JOYFUL VIEW SUBDIVISION

FINAL DRAINAGE REPORT

SEPTEMBER 28, 2021

PCD File No. MS

SHEET DR 1

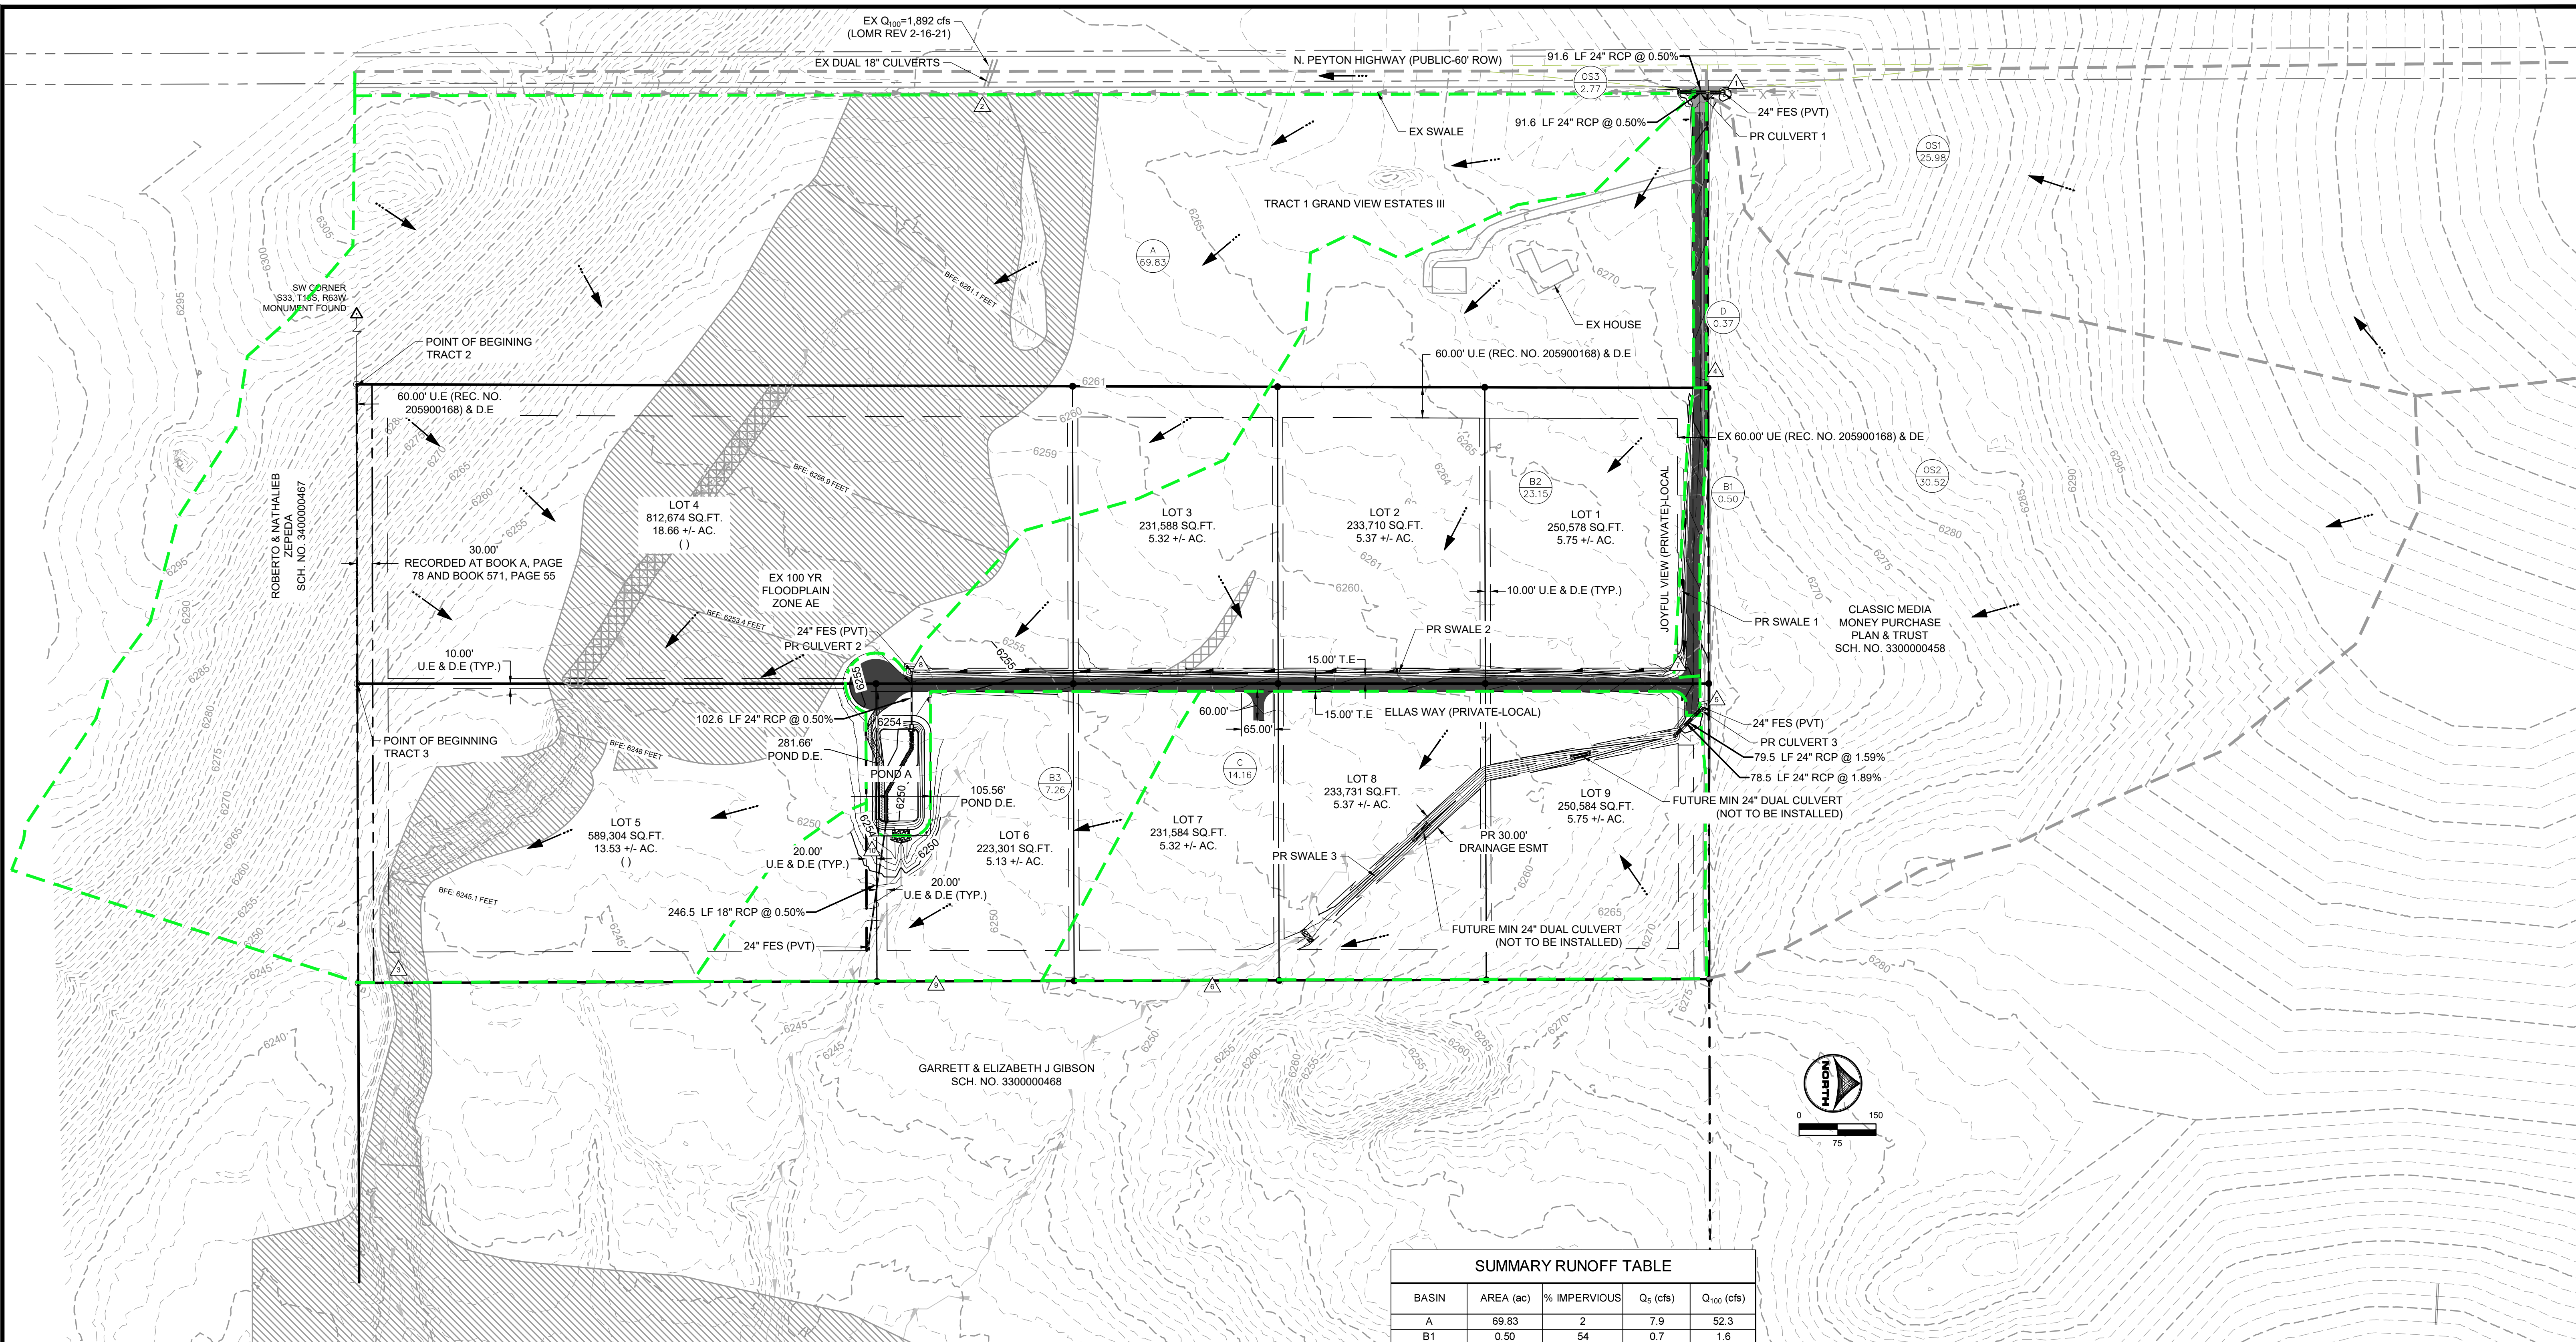
per the drainage plan OS4 and OS5 both flow into the site

DP1 is on the east side of the property and flows into Tract 4. Per the narrative, it appears that flows from DP3, OS5 and OS6 will combine at DP4. Revise accordingly

A2 is 15 acres per the drainage plan. revise accordingly

36 per the drainage plan

DRAINAGE, GRADING &
 EROSION CONTROL
 PLAN

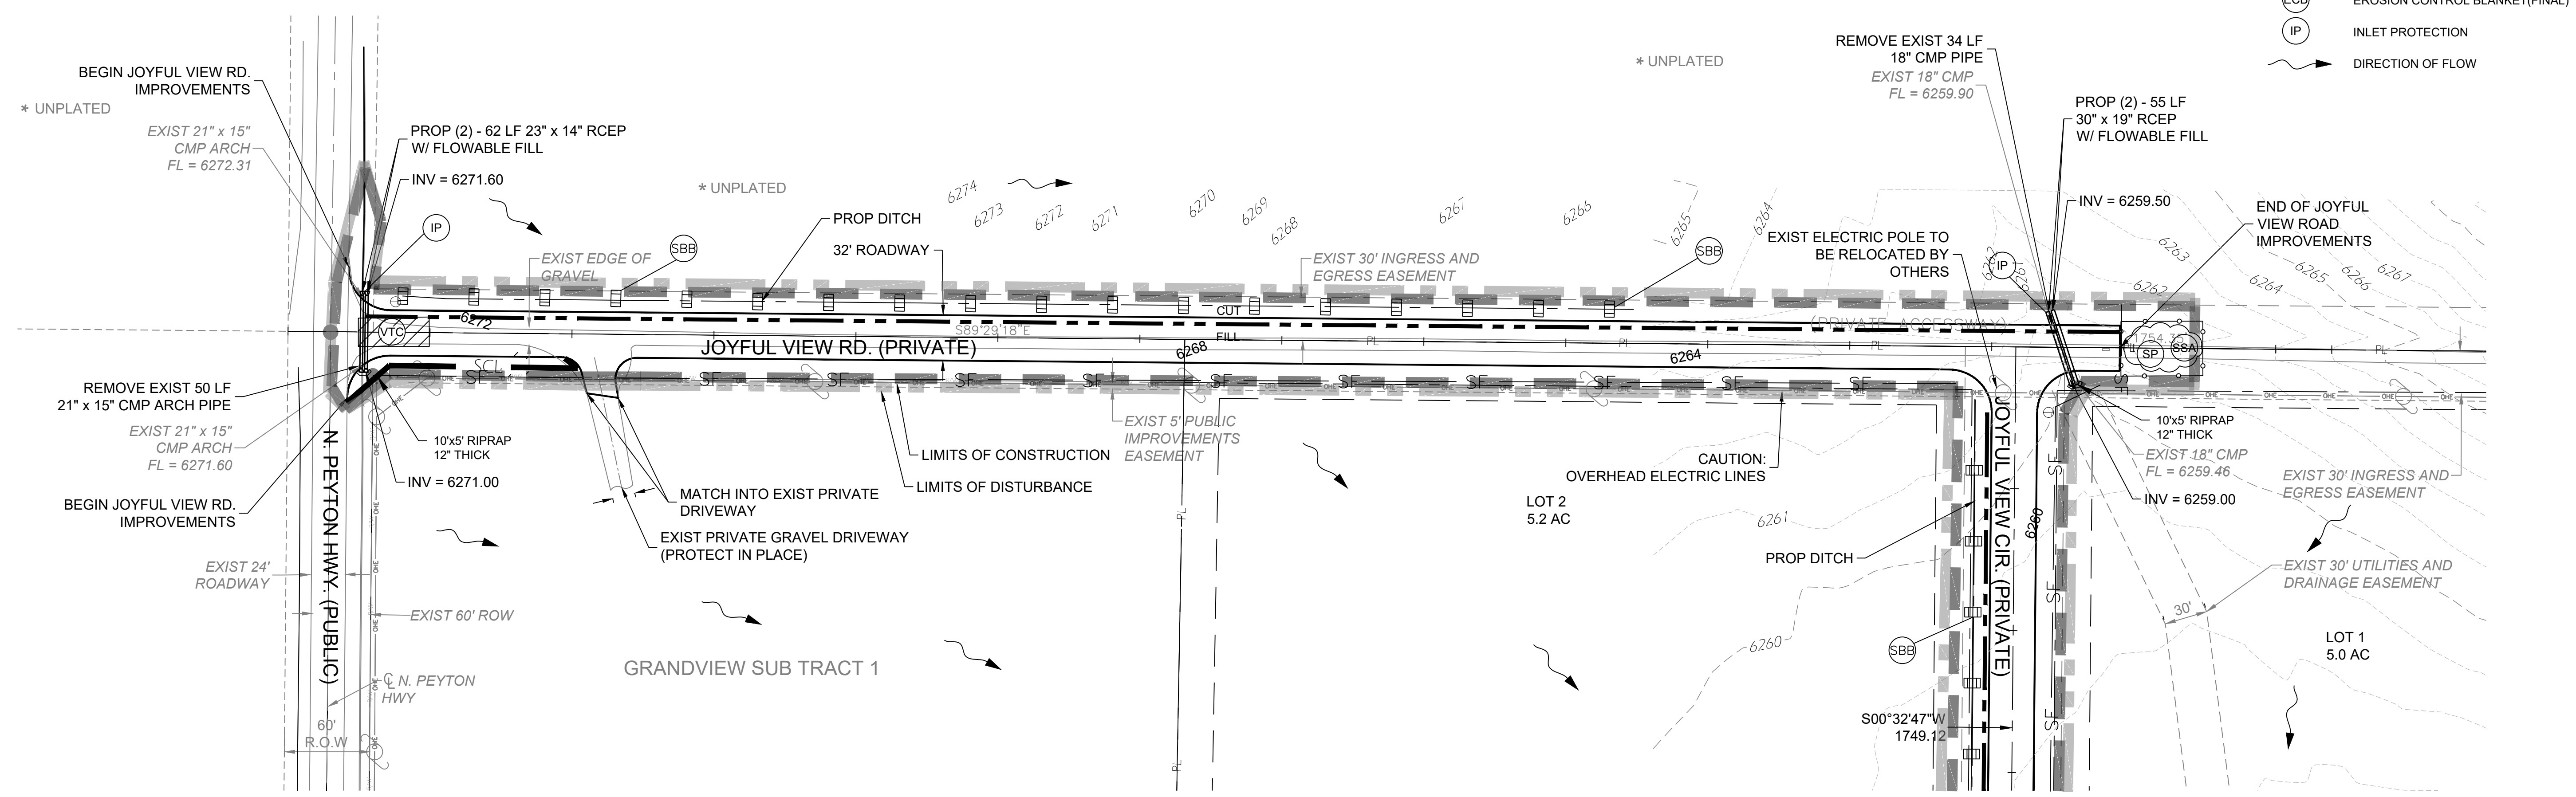
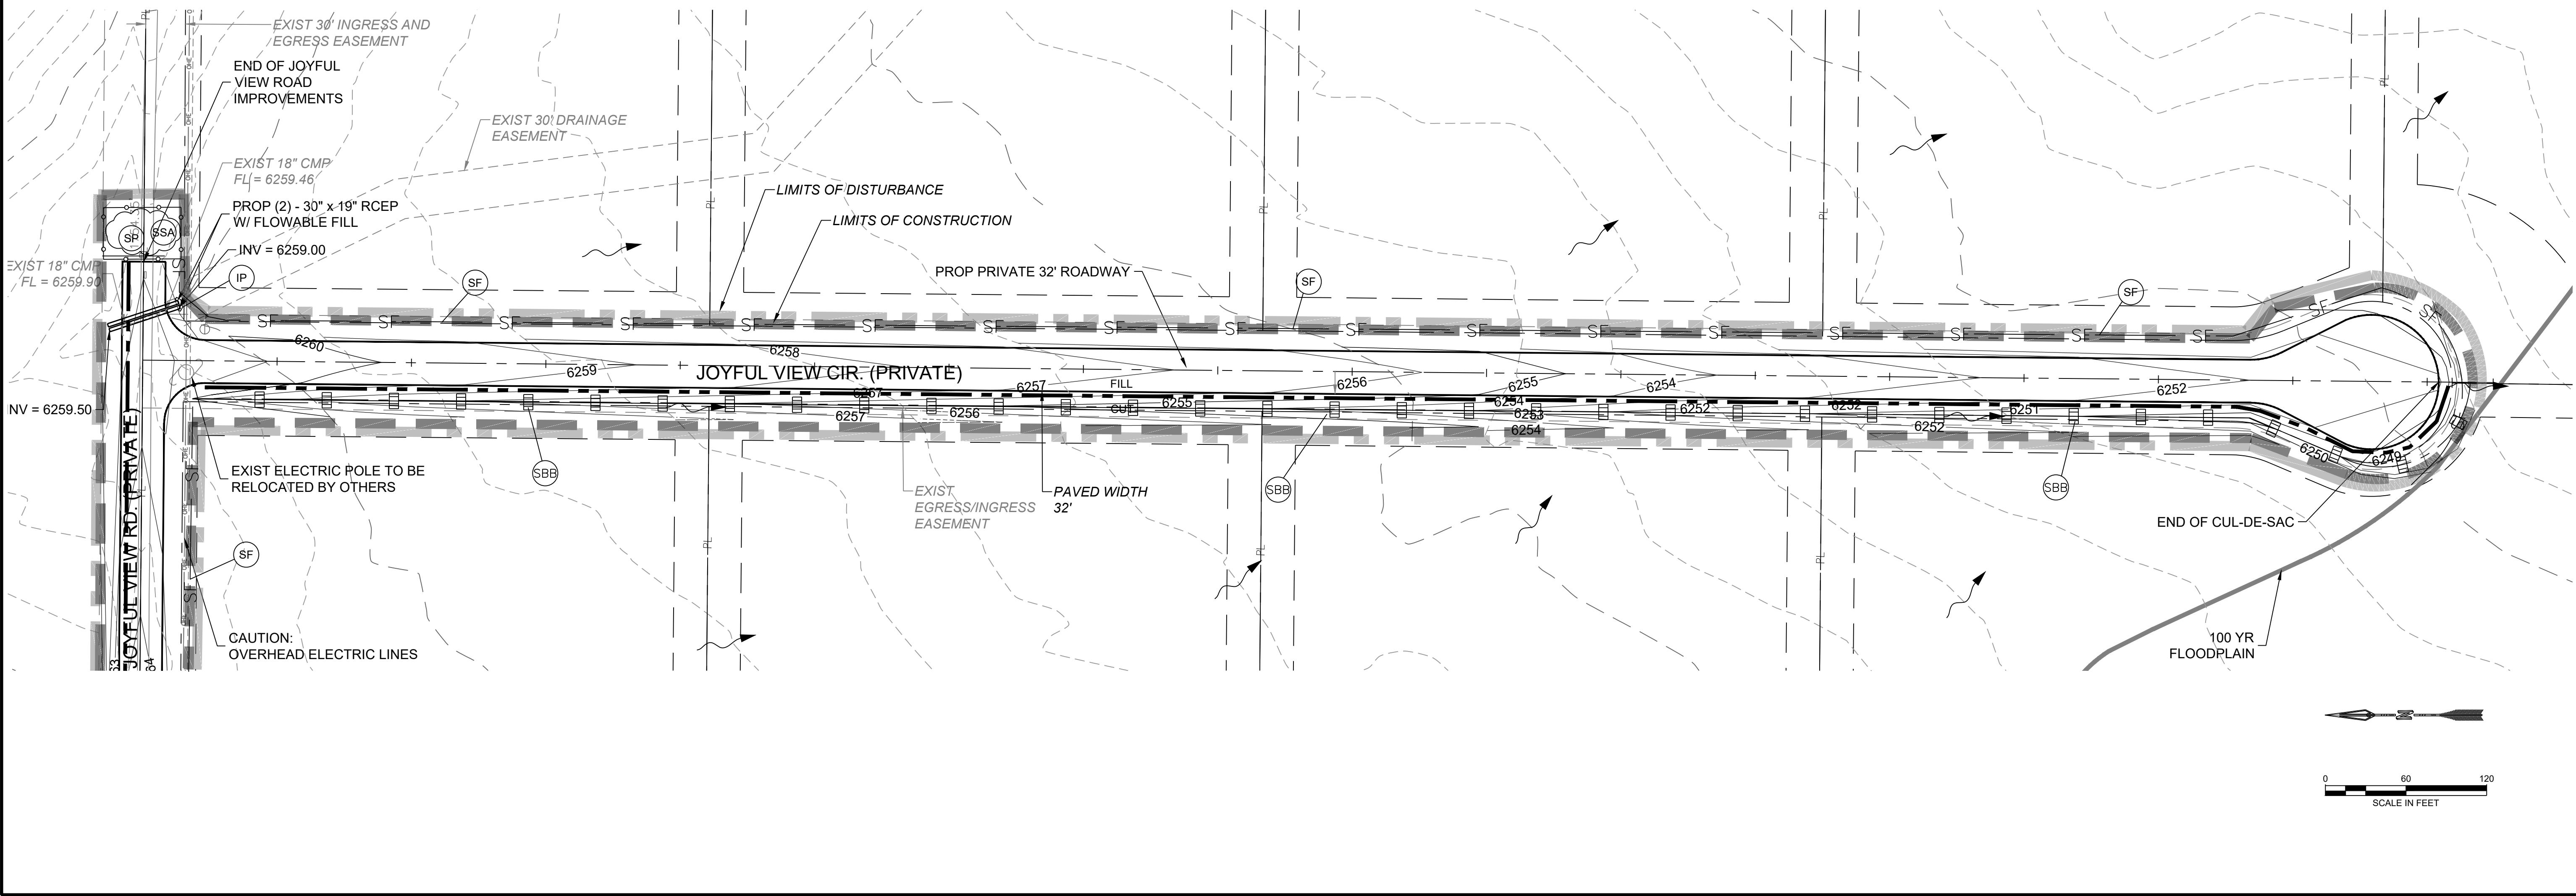
Show on GEC Plans
